An
Bord
Pleanála

Inspector's Report

ABP-303471-19

Question	Whether the development at The Man Friday Restaurant is or not development or is or is not exempted development
Location	Man Friday, Scilly, Kinsale, Co. Cork.
Declaration	
Planning Authority	Cork County Council
Planning Authority Reg. Ref.	D/310/18
Applicant for Declaration	Philip and Josephine Horgan.
Planning Authority Decision	Is not exempted development
Referral	
Referred by	Philip and Josephine Horgan
Owner/ Occupier	Philip and Josephine Horgan
Observer(s)	None
Date of Site Inspection	9 th April 2019.
Inspector	Elaine Power

(D) PERGOLA

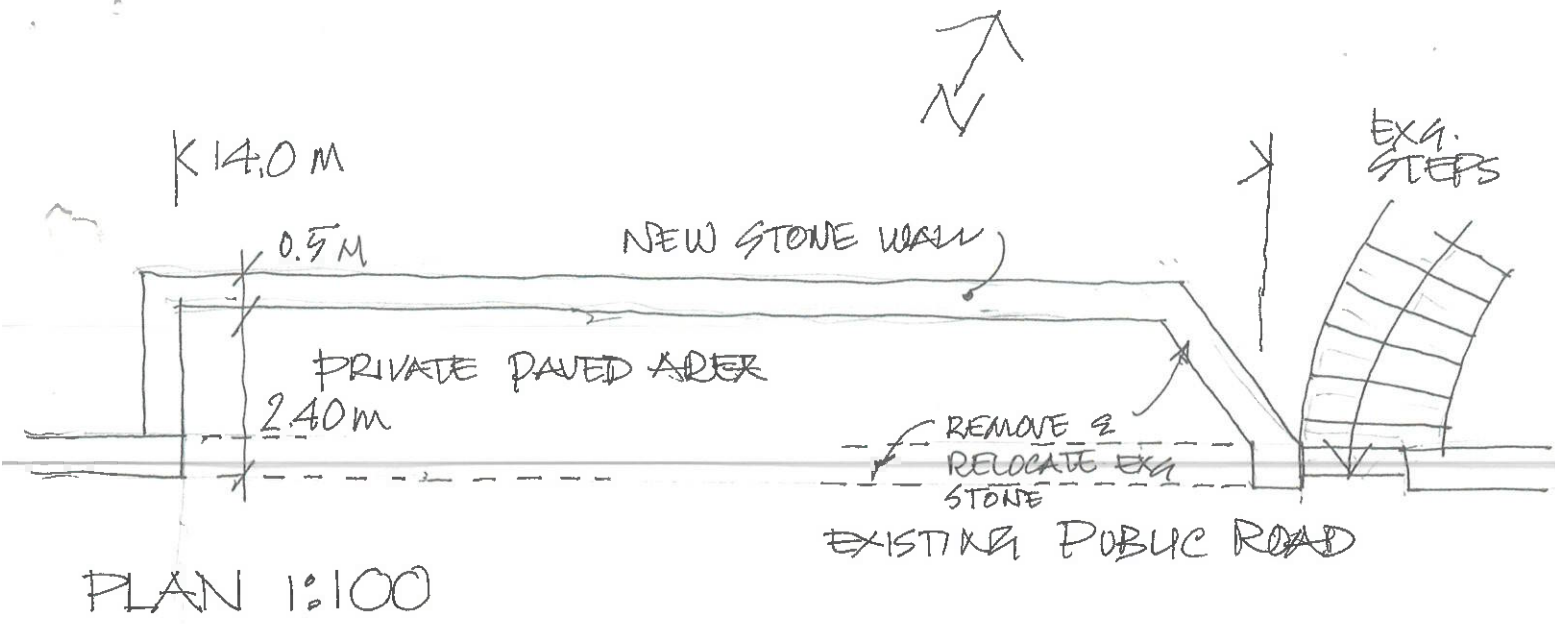
The pergola is covered and has a gross floor area of 55sqm. It is noted that permission was recently granted (13th March 2019) for the retention of the structure (Reg. Ref. 19/04071) and that it was previously subject to enforcement proceedings (EF 18/174).

The referrer stated that the pergola does not increase the capacity of the existing terrace and considers that the works consist of the laying out and use of land as an ornamental garden. Therefore, the pergola is exempted under Class 33(a). In my opinion the structure extends the commercial area of the restaurant and does not consist of the laying out of land as a park, private open space or ornamental garden. It is not, therefore, exempt under Class 33(a).

The pergola is located on a paved area adjoining the restaurant use. It is covered and accommodates tables and chairs, ancillary to the restaurant use. As the pergola provides shelter for an area that was previously open, it is my opinion that it would be

a material change of use from open space to a sheltered area for the consumption of tobacco and alcohol. Therefore, the works cannot be described as an improvement or alteration to the existing restaurant and as such do not fall within the scope of Section 4(1)(h) of the Planning and Development Act, 2000 (as amended). In my opinion the pergola is more appropriately described as the erection of a new separate structure which would result in an intensification of the restaurant use and would, therefore, be a material change of use. As such, the pergola to be retained is development which is not exempted development.

The painted advertising sign 'Man Friday' is located on the northern roof slope. It is noted that permission was recently granted (13th March 2019) for the retention of the advertising (Reg. Ref. 19/04071), which was previously subject to enforcement proceedings (EF 18/174). Scaled drawings have not been submitted with the referral. However, the drawings submitted show the advertising as being located between approx. 2.5m and approx. 4.5m above ground floor level. The dimensions of advertising area is shown as approx. 3.7m in width by approx. 1.8m in height. The total surface area of the advertising is indicated as 1.7sqm.

The referrer has requested that the words 'Man' and 'Friday' be assessed separately. In my opinion, the words should be assessed together as they are advertising for the restaurant and not stand-alone signage.

Class 1 of Schedule 2, Part 2 sets out a number of conditions and limitations relating to advertisements. Condition and limitation 2 requires that the total area of any advertising exhibited on a building, other than the front elevation, shall not exceed 1.2sqm. Having regard to the information submitted it is estimated that the roof advertising is approx. 1.7sqm. Therefore, condition and limitation 2 is exceeded.

Condition and limitation 8 requires that no advertisement shall contain any letter exceeding 0.3m in height. From the information submitted it is estimated that each of the individual letters are approx. 0.9m in height. Therefore, the advertising exceeds this limitation.
